# Mallard Pass

### Summary of Applicant's Oral Submissions at ISH1 & Appendices

**Deadline 4 - July 2023**

EN010127  
EN010127/APP/9.30  
Revision 0

Figure 2-1: Construction Compound Overview

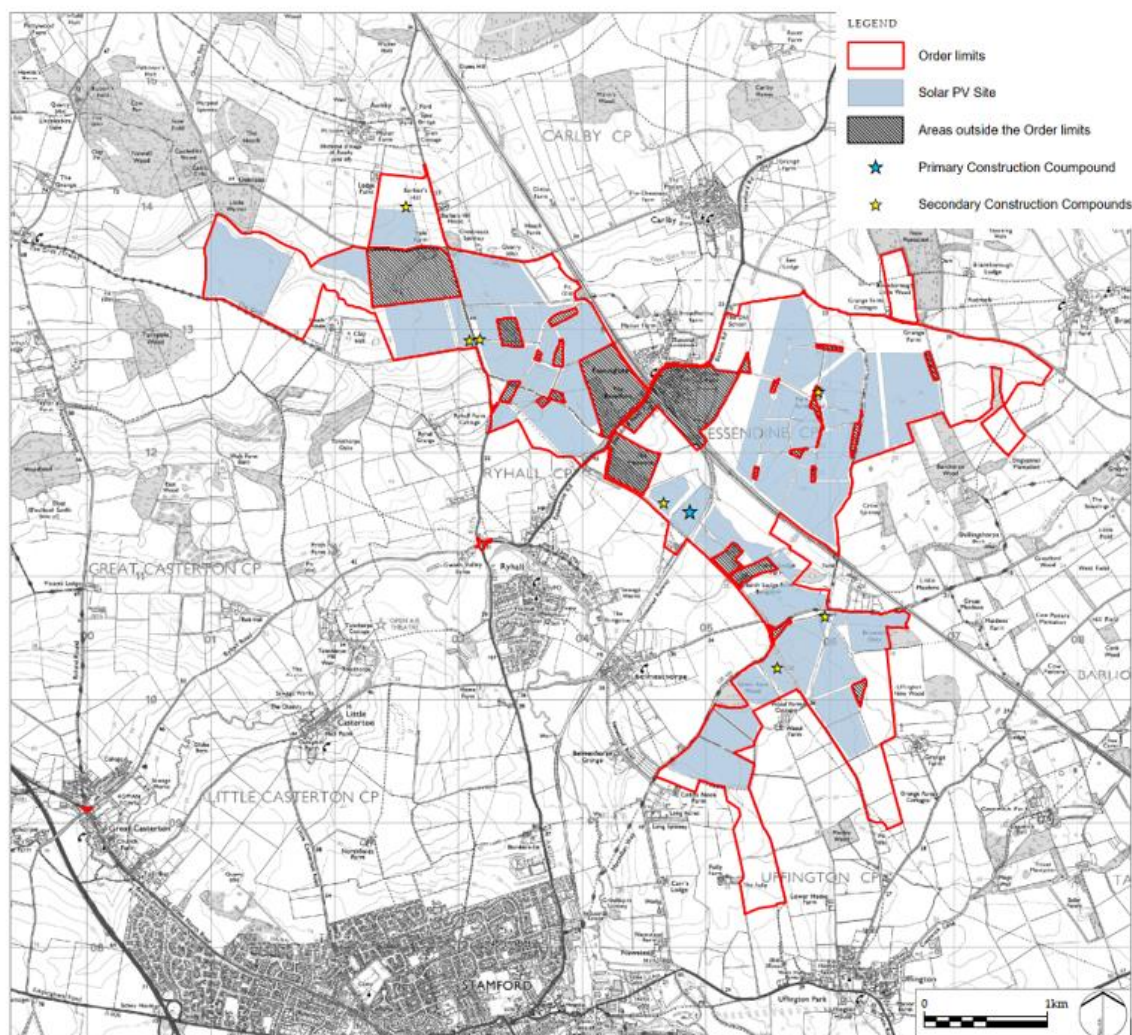
Item	ExA Question/ Context for Discussion	Applicant's Response
		<p>The ExA asked the Applicant how many parking spaces will be required for the primary construction compound.</p> <p>Mr Pile, for the Applicant, explained the Applicant would confirm this at Deadline 4 or in the written summary of oral submissions.</p> <p><b>Post Hearing Note:</b> <i>The Applicant can confirm that within Section 2.4 of the oCTMP, provision for 150 spaces has initially been allowed for at the primary construction compound. The parking spaces may be relocated to other parts of the Order Limits, subject to the construction methodology and that further information on the temporary car park arrangements will be confirmed within the detailed CTMP pursuant to Requirement 13 of the DCO. The oCTMP has been updated at Deadline 4 to provide further into on this.</i></p> <p>Mr Fox, for the Applicant, referring back to earlier discussions regarding the primary compound and the appearance of the substation explained that a cross section and illustration of the primary compound would be considered by the Applicant but that anything prepared would be indicative only. Mr Fox emphasised that the substation itself is a piece of electrical infrastructure and there are therefore, with the exception of paint, a limited number of controls that could alter the appearance of the substation. The key is the surrounding mitigation and Design Guidance and the Applicant is proposing that the substation would be subject to screening vegetation.</p> <p>The ExA commented that paragraph 4.6 of draft EN1 does talk about the consideration of design and sensitive use of materials.</p> <p>Mr Fox, for the Applicant, confirmed that the Design Guidance stipulates that colours and materials for the build must be sensitive.</p>
